CITY OF ALBUQUERQUE

**Re: Presbyterian Hospital Main Drive Entry Relocation
Erosion and Sediment Control Plan
Engineer's Stamp Date 11-17-16 (K15E005)**

Based upon the information provided in your submittal received 11-18-16 the above referenced plan is approved to be included in the SWPPP and to apply for an ESC Permit for grading for the site work.

**EROSION
& SEDIMENT
CONTROL PLAN**

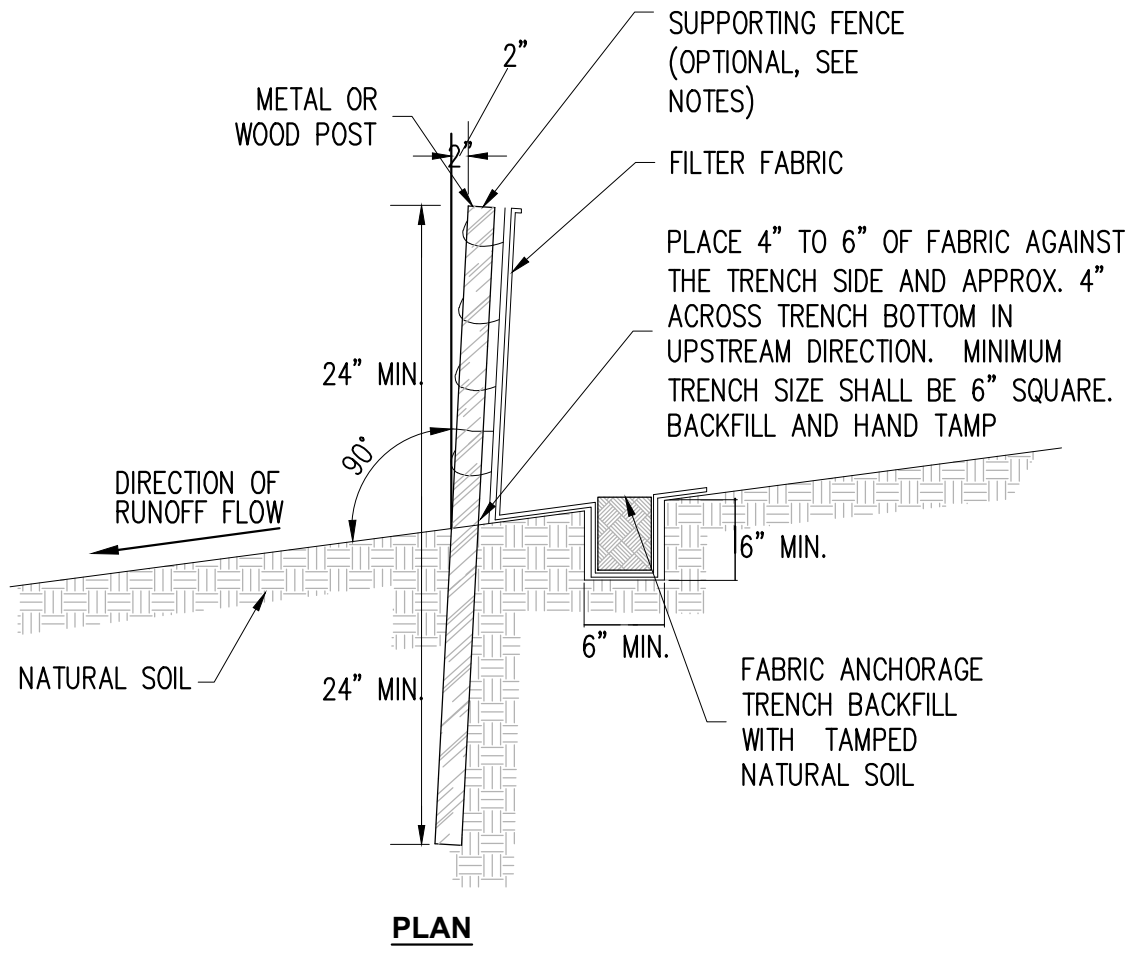
Additional BMPs will be required for the construction in Spruce Street.
